KITTITAS COUNTY FIRE MARSHAL'S OFFICE

October 13, 2010

Re: AMENDED COMMENTS for Vista West Performance Based Cluster Plat (LP-09-00001)

VISTA WEST
PERFORMANCE BASED CLUSTER PLAT
A PTN. OF THE NORTH 1/2 OF SEC. 33, T.20N., R.14E., W.M.
KITITAS COUNTY, WASHINGTON

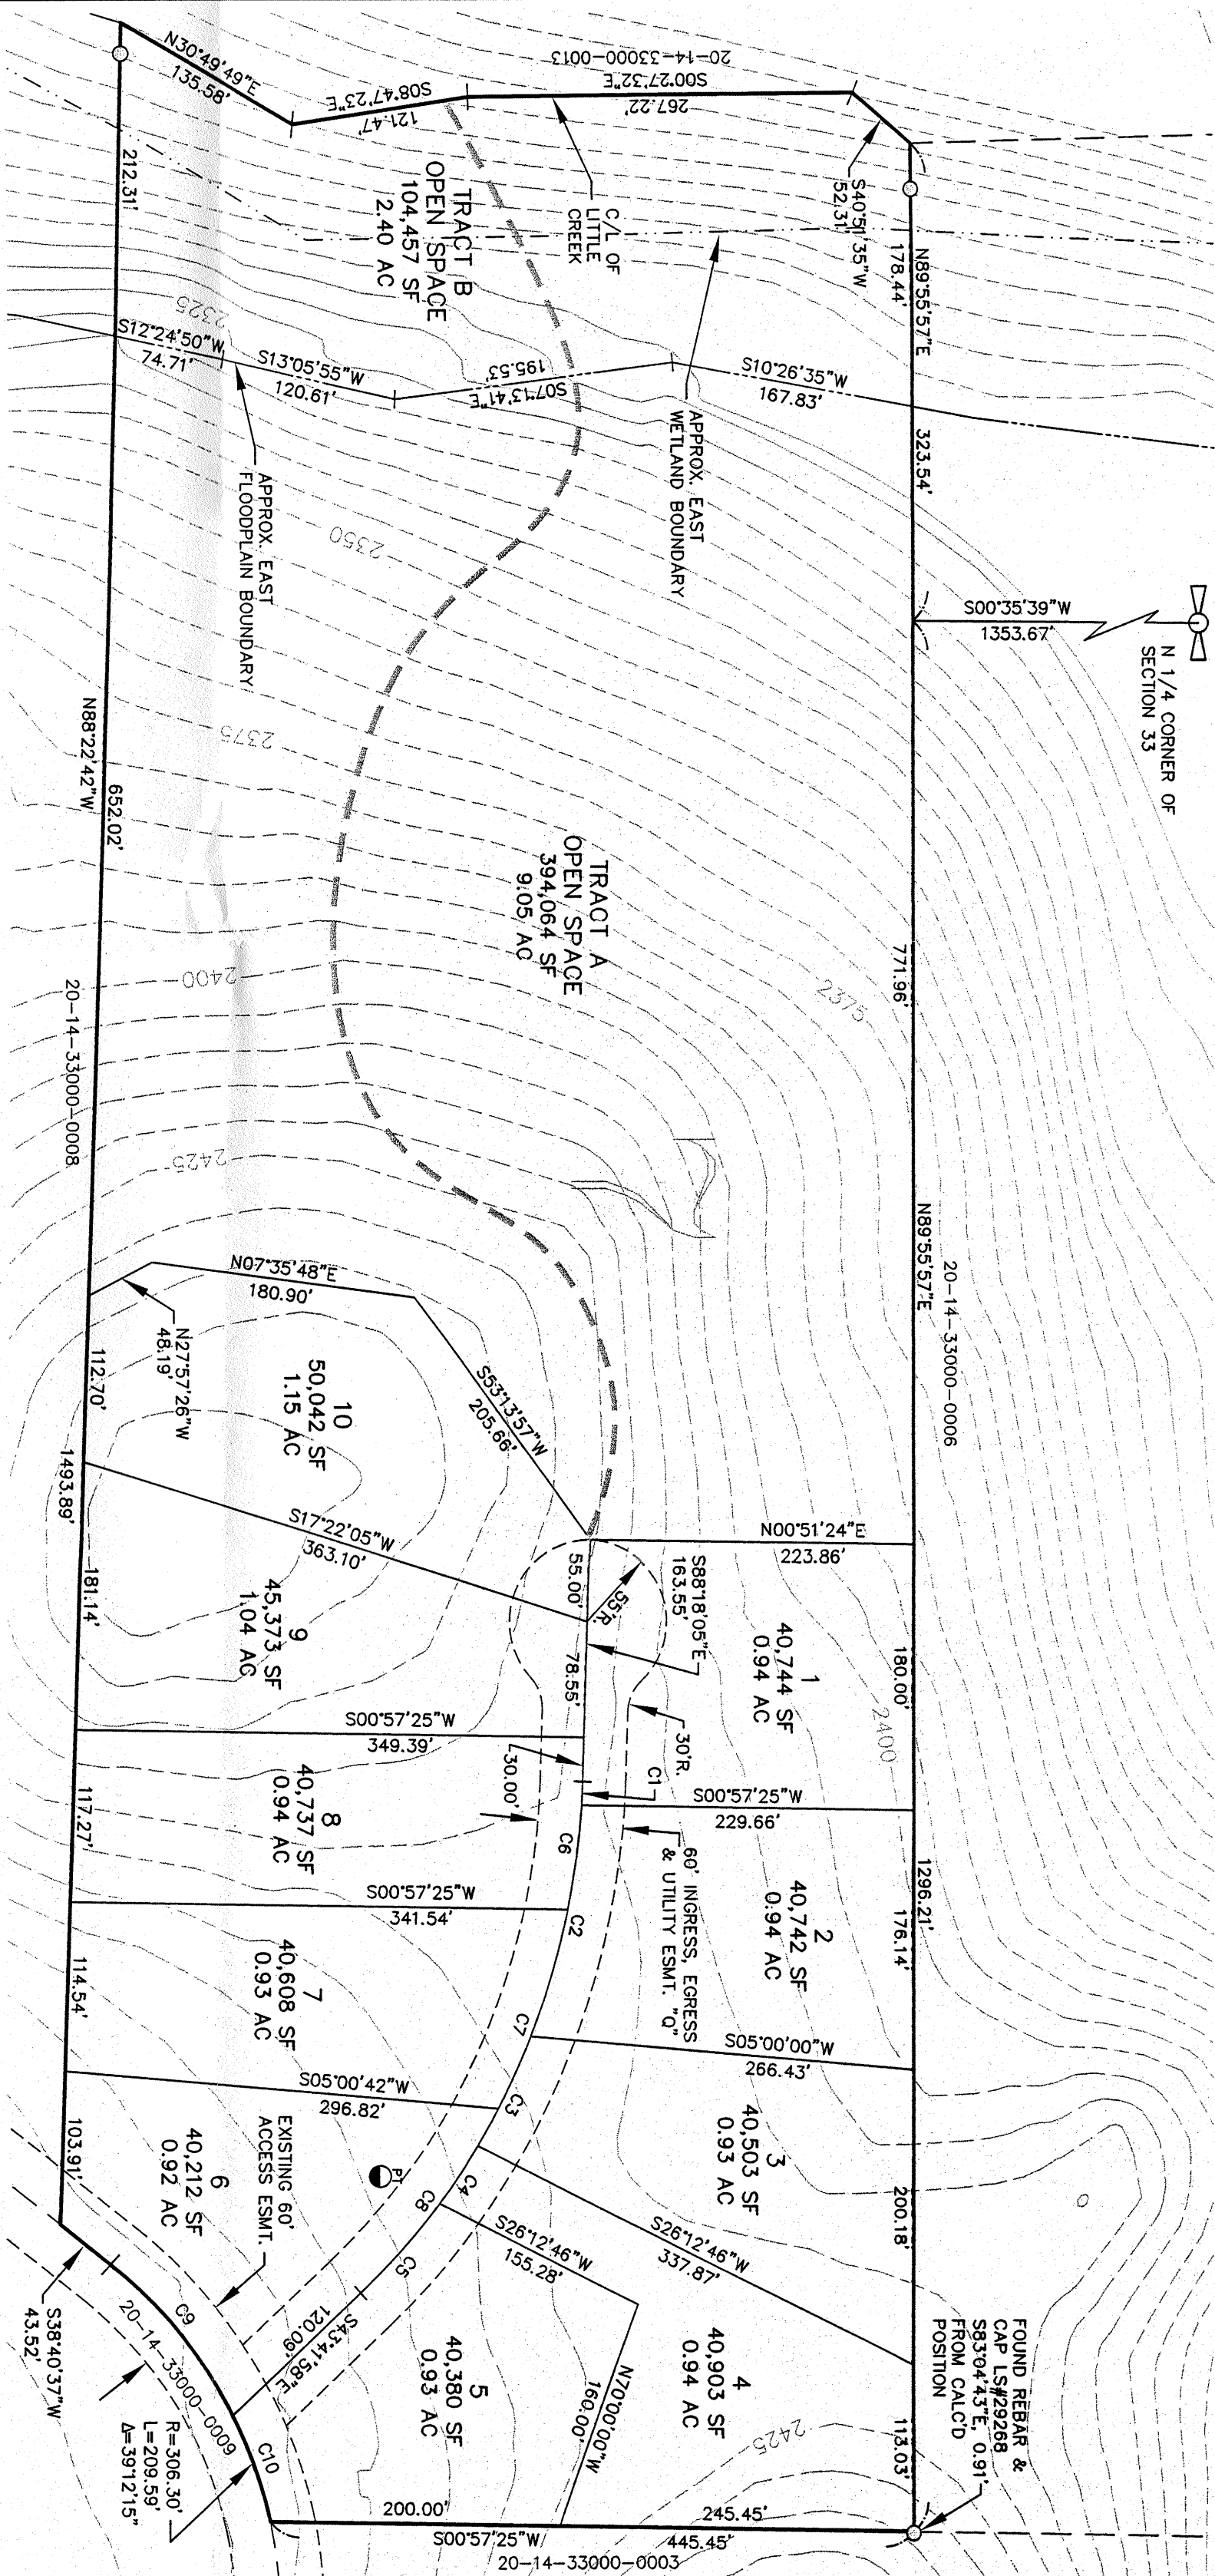
- No fire apparatus access lane shall have a slope greater than 12%. A Variance Permit will be required for any slopes or grades greater than allowed by County Code.

- "No Parking-Fire Lane" signs must be posted per Fire Marshal requirements on all cul-de-sacs.
- Secondary access is required, or each residence accessed off of the single access road shall be required to have sprinkler protection as required by the County Fire Marshal's Office, with all associated permits issued. The sprinkler requirement shall be noted as a plat note on the final plat.
